**Sydney One Project, 1 Alfred St, Sydney, Tower B: Letter of Support, Fire Safety Engineering**

Please find below our fire engineering statement to accompany the Development Application (DA) for the proposed Sydney One Project, Tower B at 1 Alfred St, Sydney, NSW.

drawing title
INDICATIVE DRAWING
BASEMENT 1

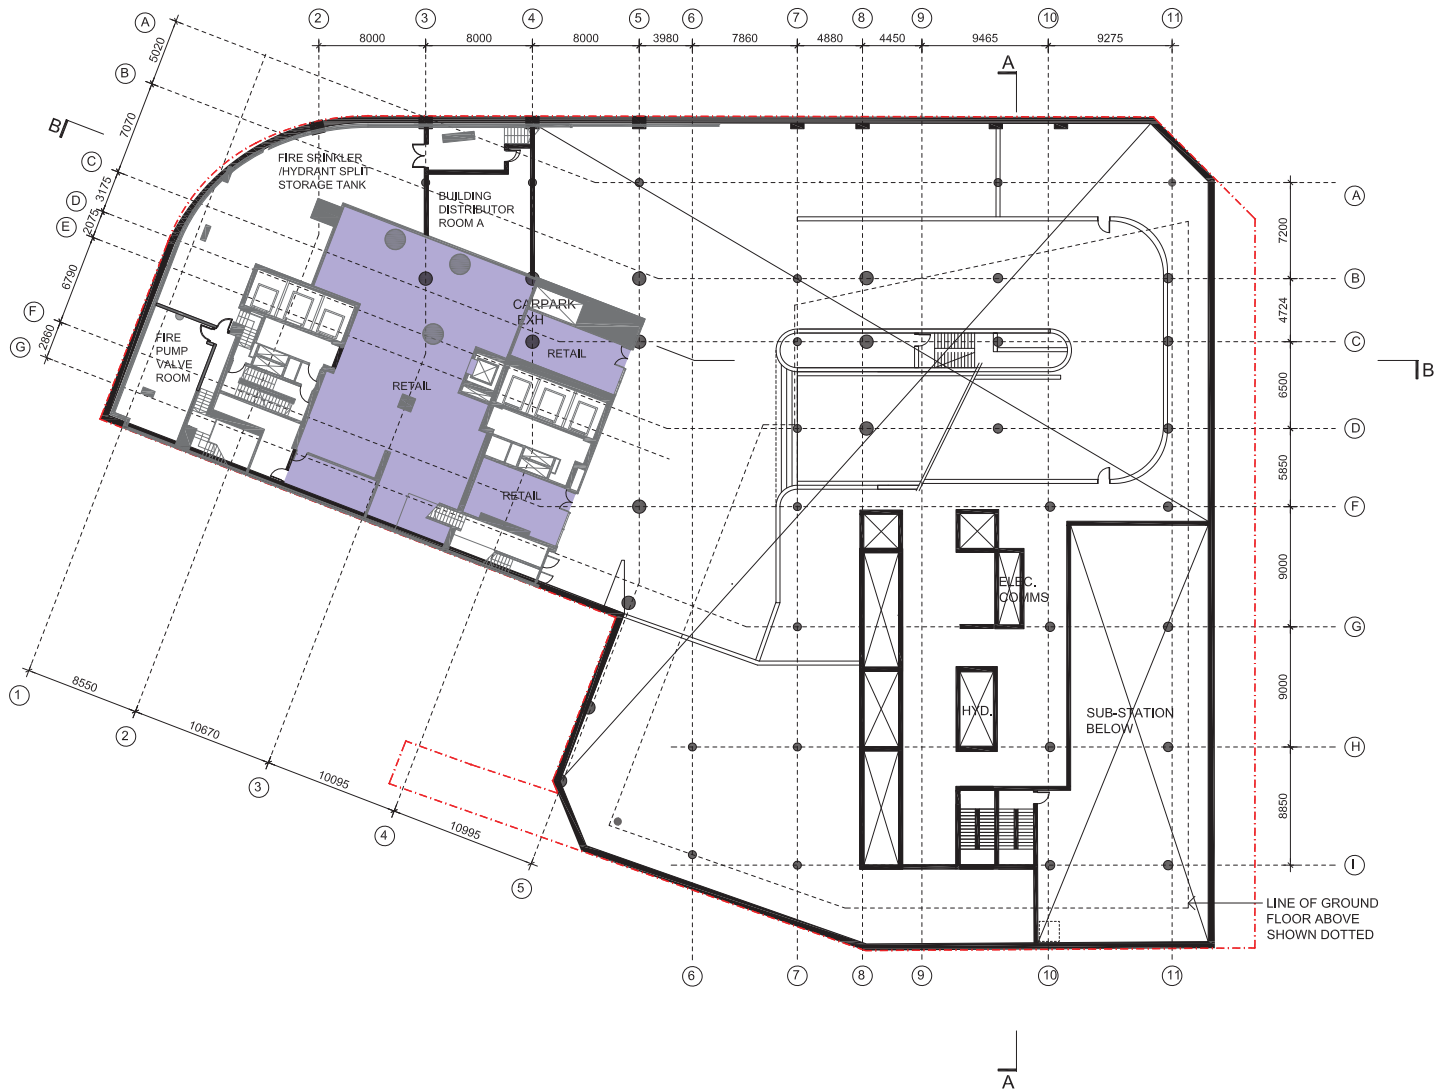
8.	Spec E1.5 – Fire sprinkler systems  (EP1.4)	The sprinkler valve room will be located below ground on Level B1, with no direct egress out to a road or open space.	The alternative solution is proposed based on the provision of fire stairs from the Ground level near the main entry of Tower A, to directly access the Level B1 sprinkler valve room. Additional directional signage will be provided.

drawing title
INDICATIVE DRAWING
HOTEL LOWER GROUND

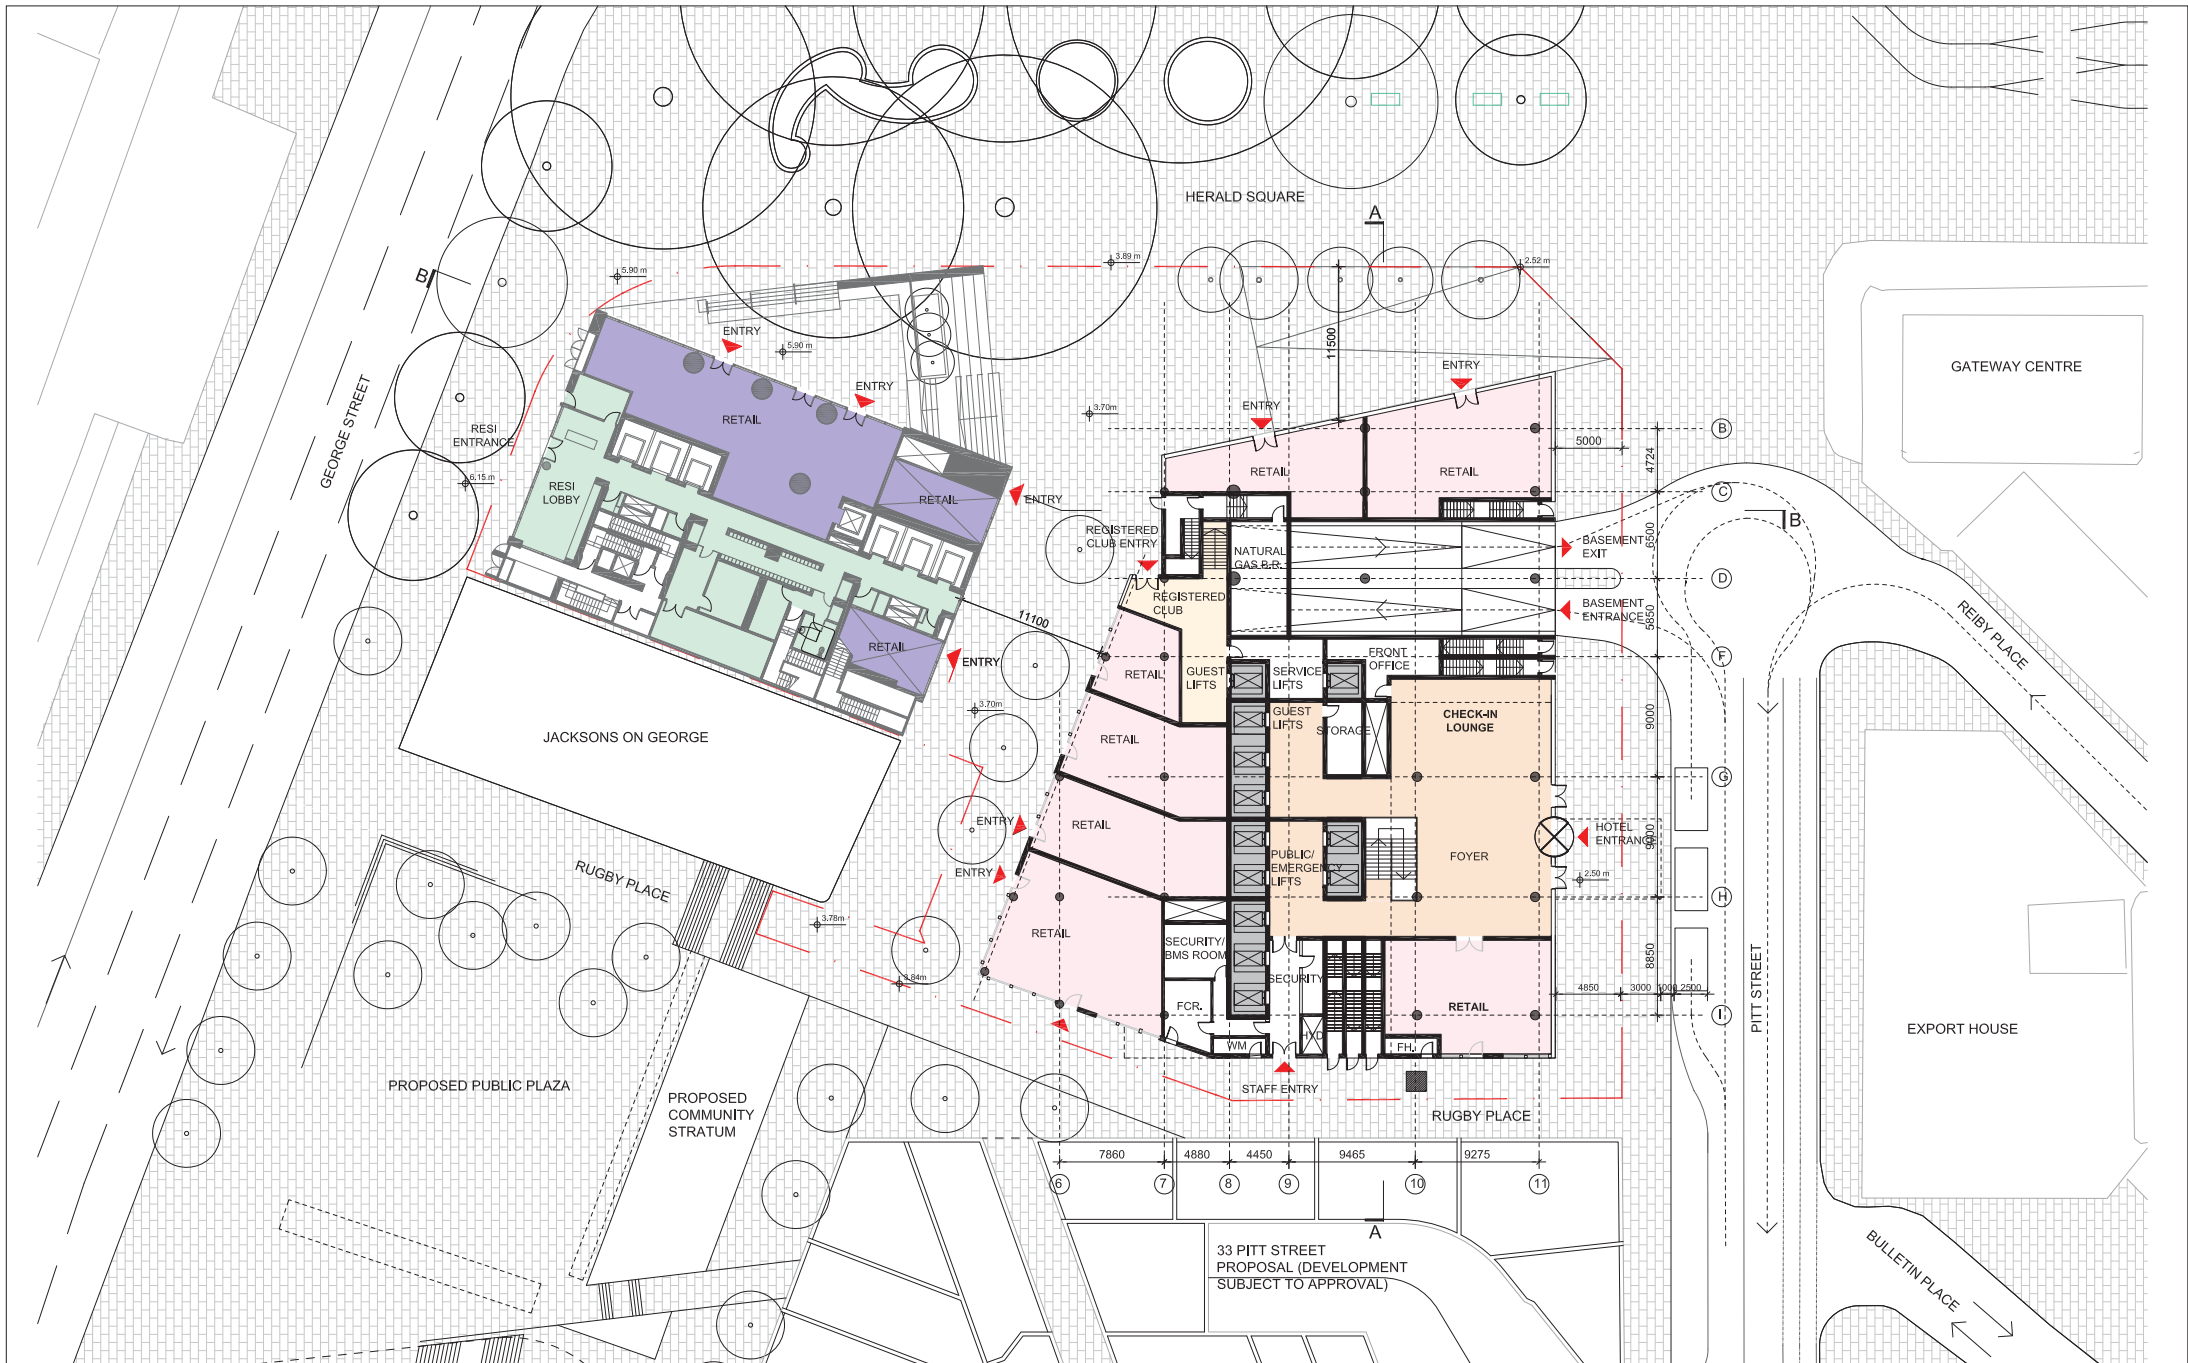
3.	D1.2 – Number of exits (DP4, EP2.2)	The Ground level retail areas with a floor area < 200 m <sup>2</sup> have only access to a single exit, where two is required by the BCA.	The alternative solution will be based on the size, location and use of the retail spaces, and the provision of fire safety systems.
